Tel: 01903 737756
Email: planning@arun.gov.uk
www.arun.gov.uk/planning
Please ask for: Mrs D Johnson
Email: daun.johnson@arun.gov.uk
Telephone: 01903 737762
Our Ref: AL/10/26/PL
Your Ref:
Date: 19th February 2026

Application for Planning Permission

Development: Installation of 7 solar panels on mobile home roof. This application is in CIL Zone 3 (Zero Rated) as other development.
Location: 9 Old Canal Residential Park Lidsey Road Bognor Regis PO22 9PN

ROOF PLAN

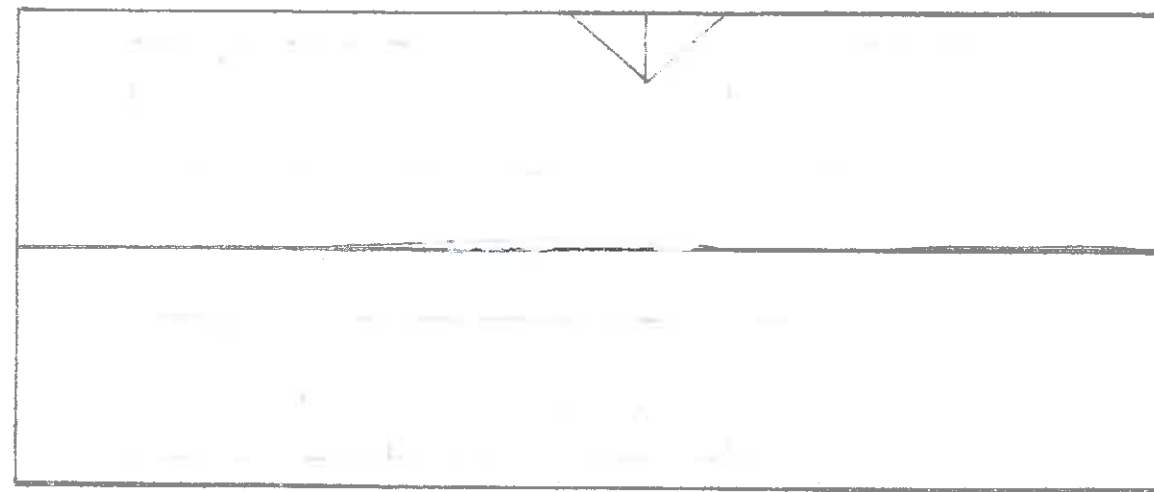
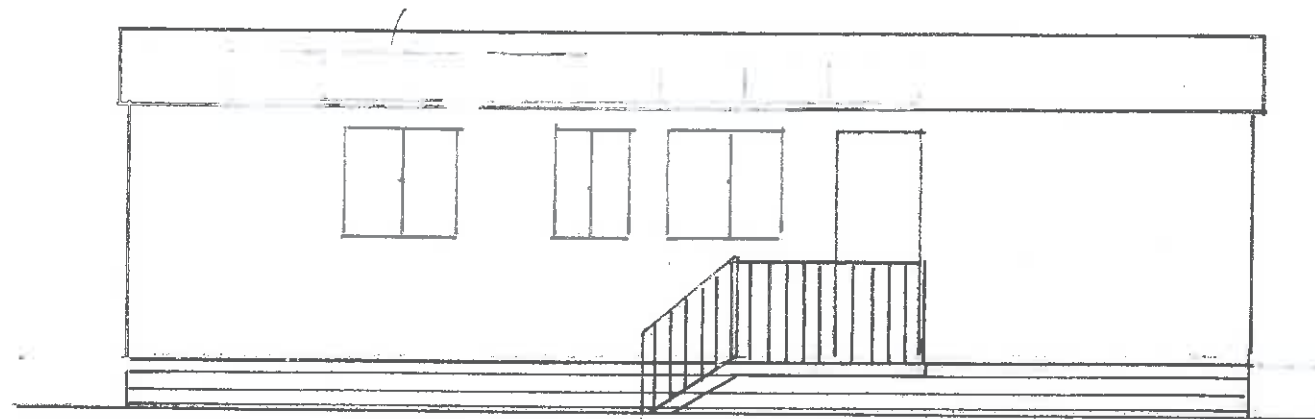
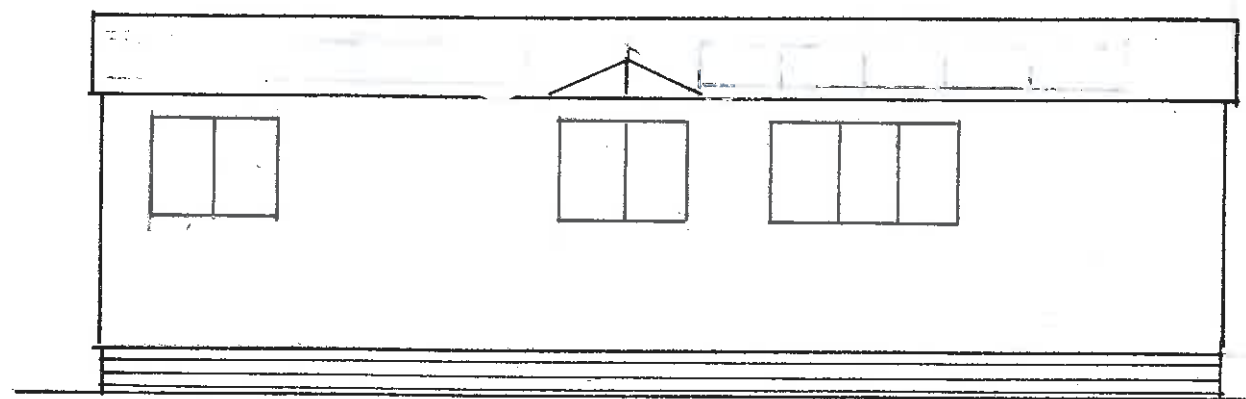
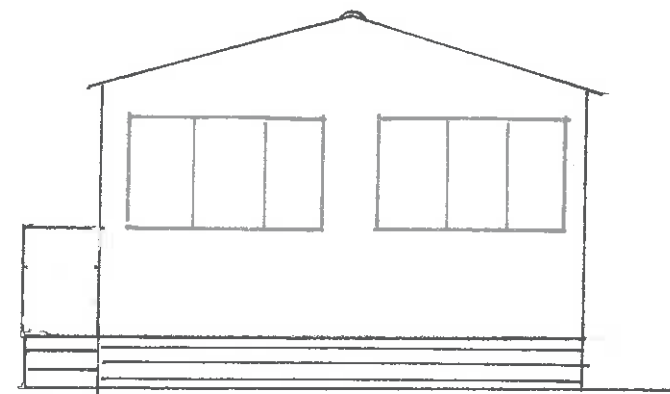
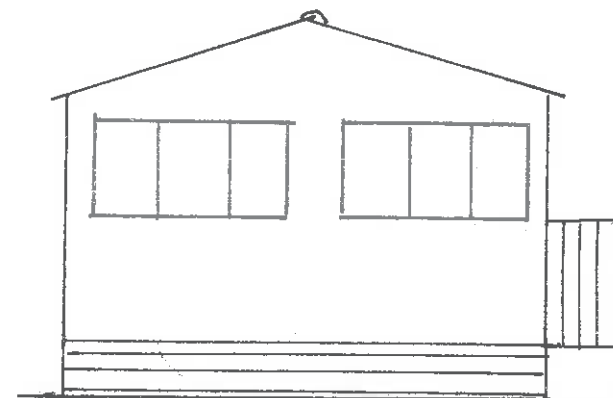
The description provided states 7 solar panels, however, there are more than 7 on the roof plan. Please confirm how many solar panels are being proposed.

BLOCK PLAN 1:500 0 5 10 15 METRES

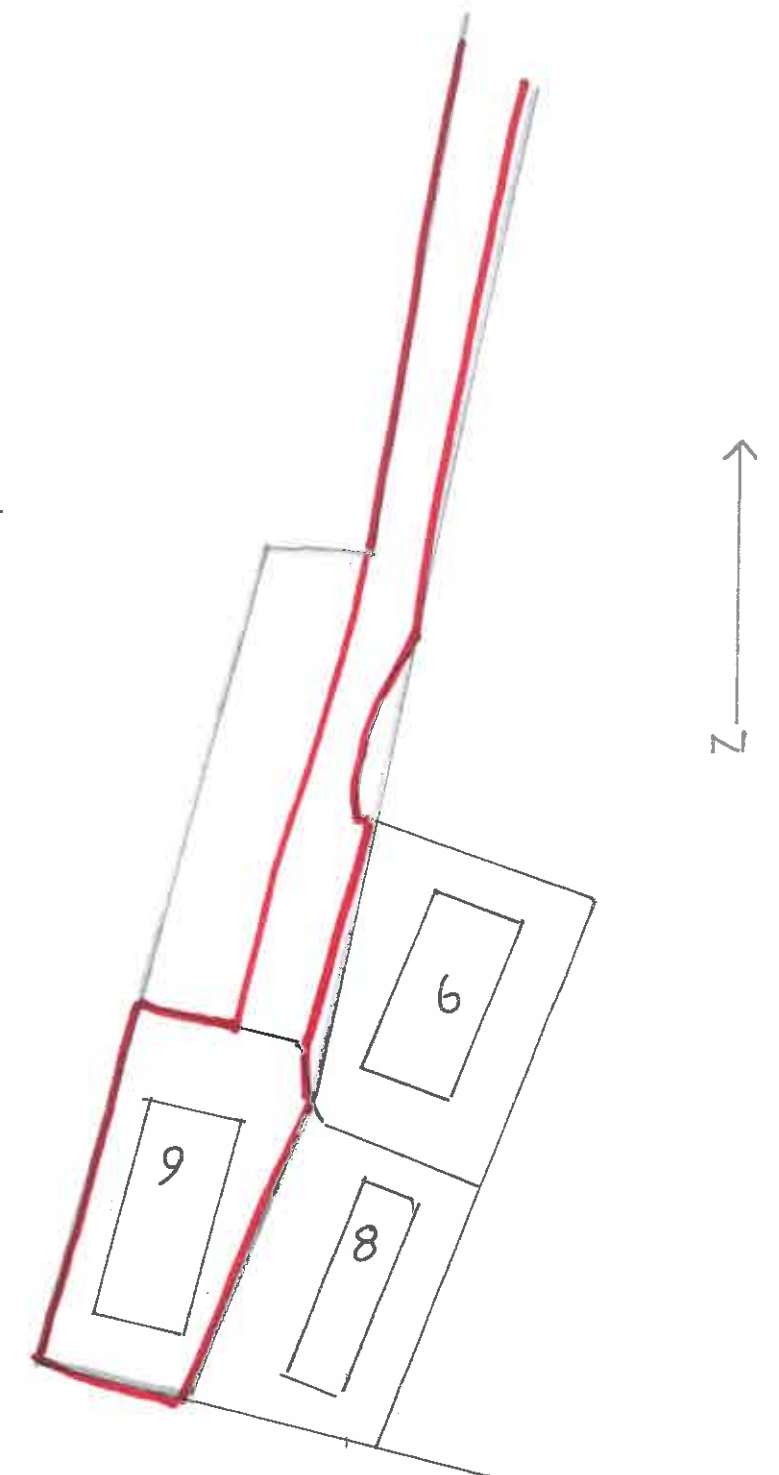
Location Plan

Please provide one named road.
